**Project Name: Cathedral Pines, Filing 6-Lot 1 & 2 Replat**

**Project Number: VR-17-004**

**Description:** Approval is being requested for the vacation and replat of the common lot line between Lot 1 and 2 of Cathedral Pines, Filing #6. The address of these properties is 4090 and 4120 Foxchase Way in Section 02, Township 12 South, Range 66 West.

CATHEDRAL PINES SUBDIVISION FILING NO. 6 AMENDED

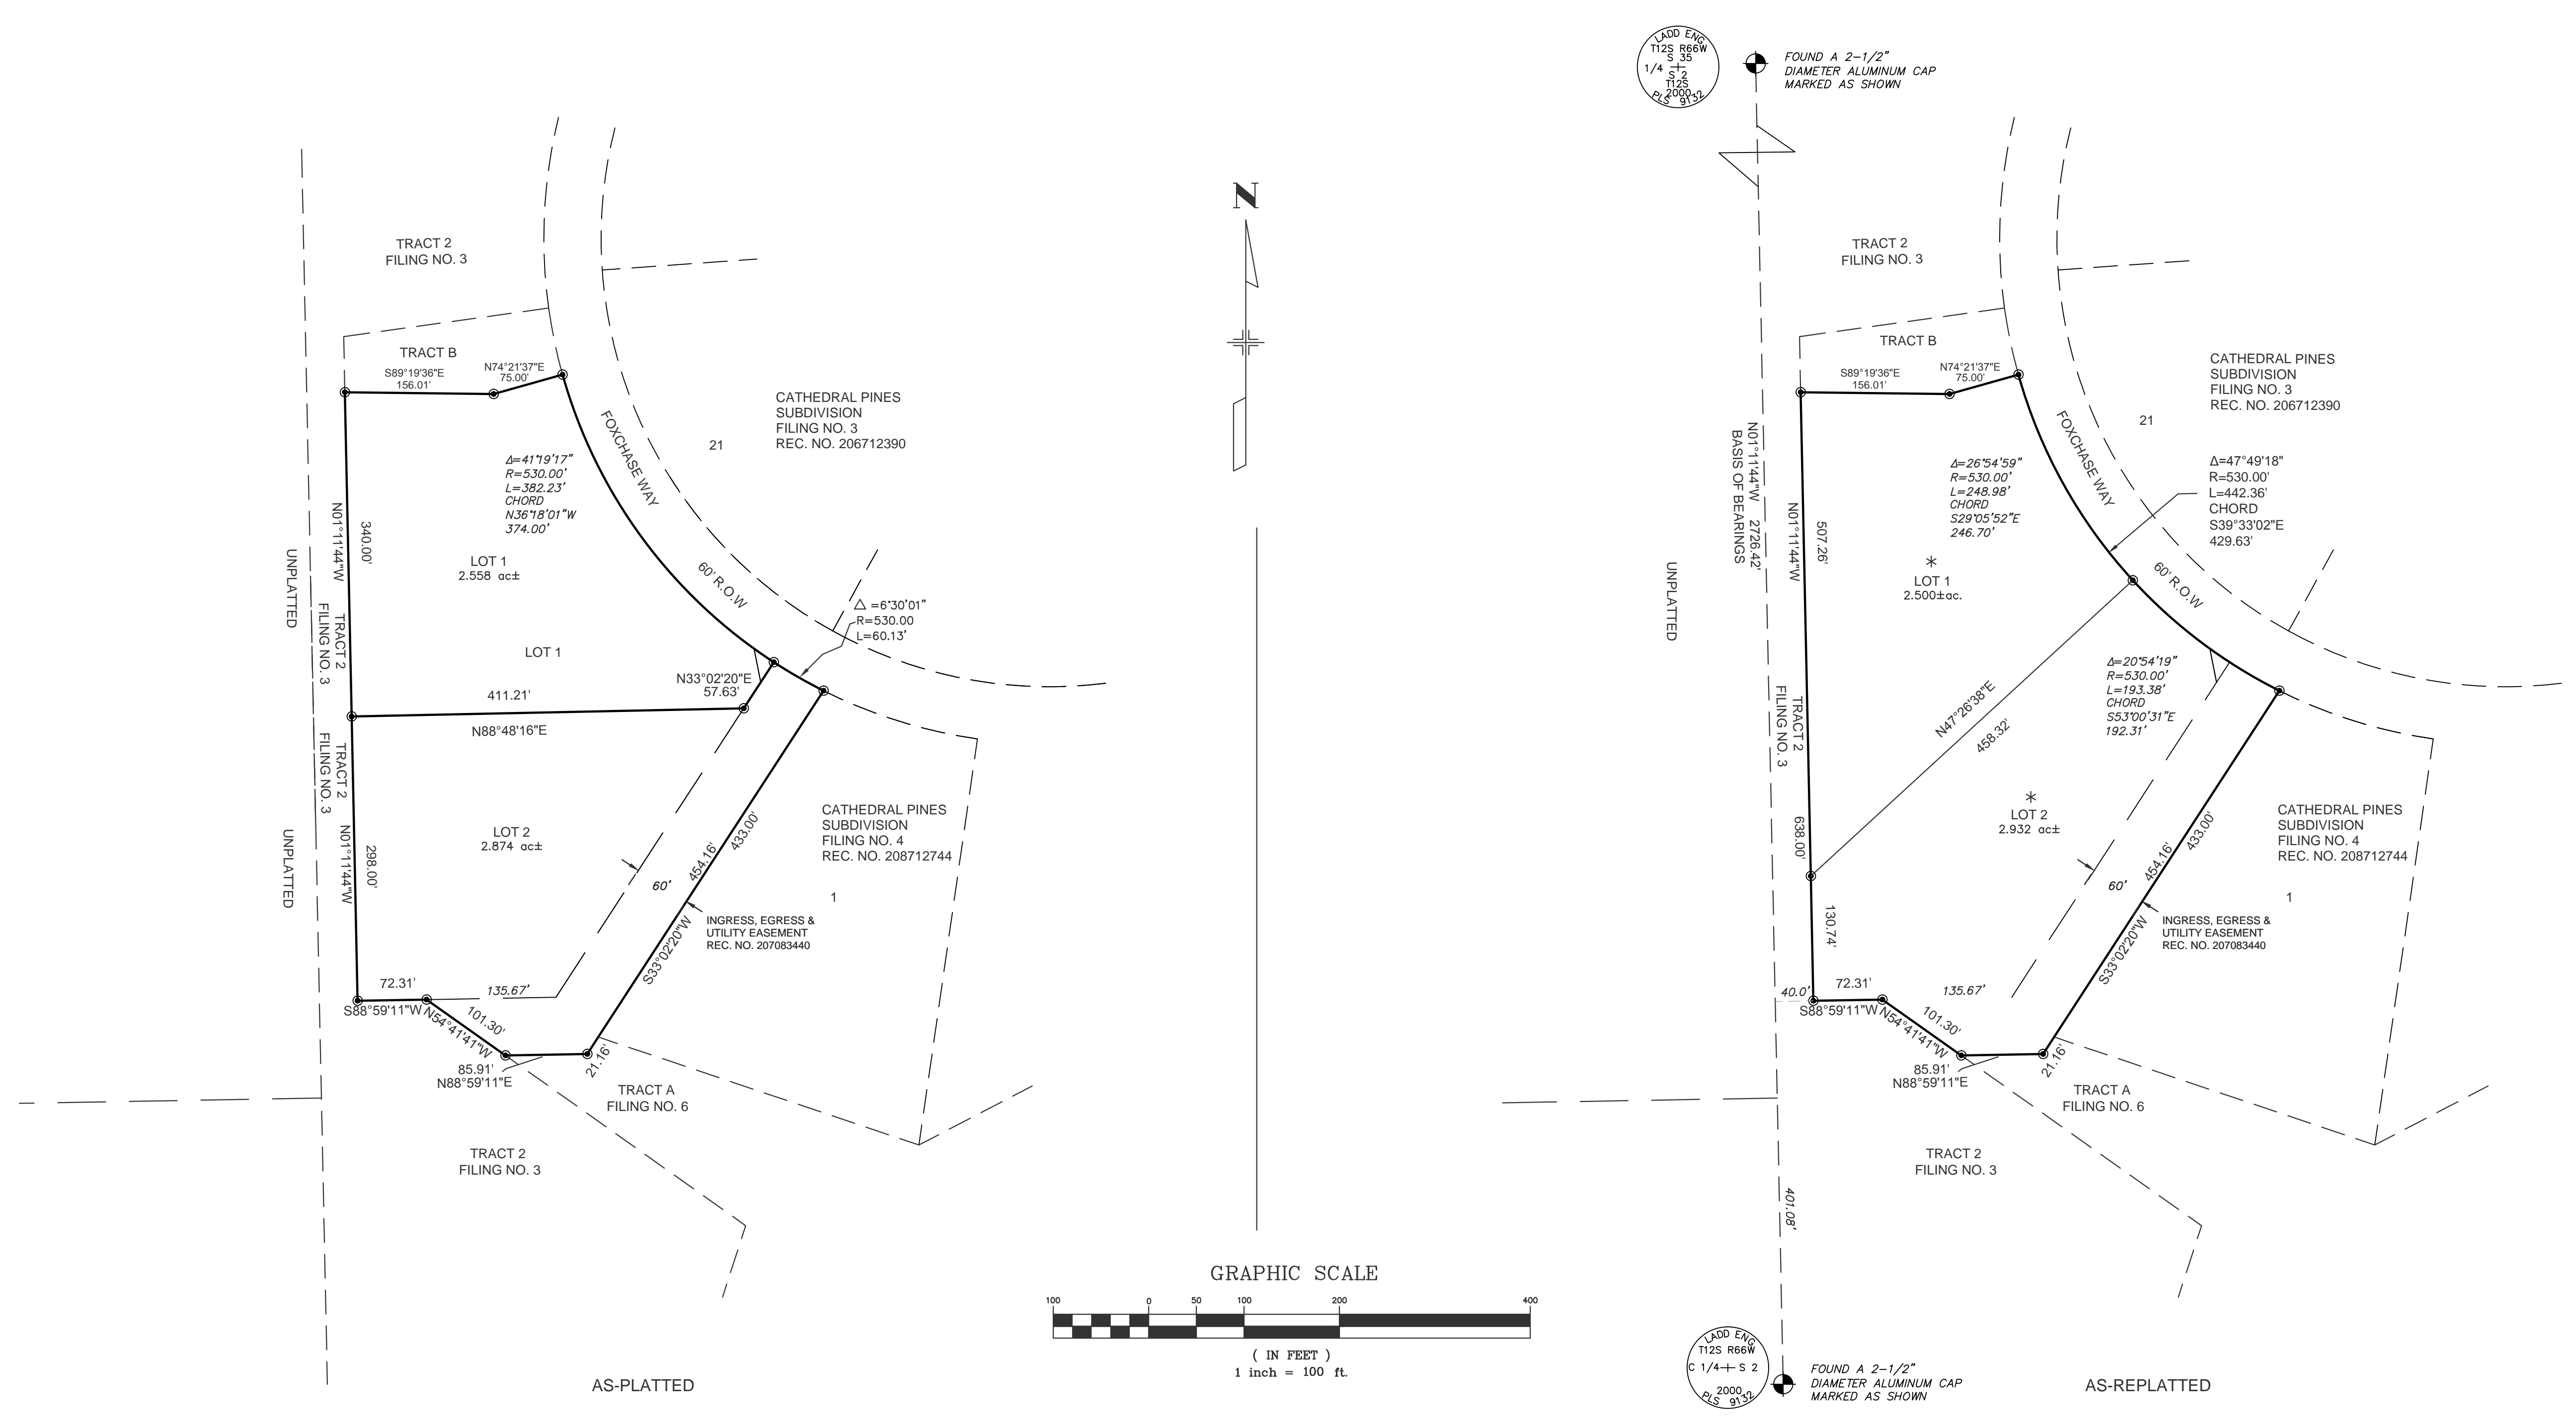
MVEA requests the platting of the utility easements shown on the Final Plat of Cathedral Pines, Filing #6 of fifteen (15) foot front lot utility easement and ten (10) foot side and rear lot line utility easement. Also, please show the existing MVEA facilities with easement on the plat.
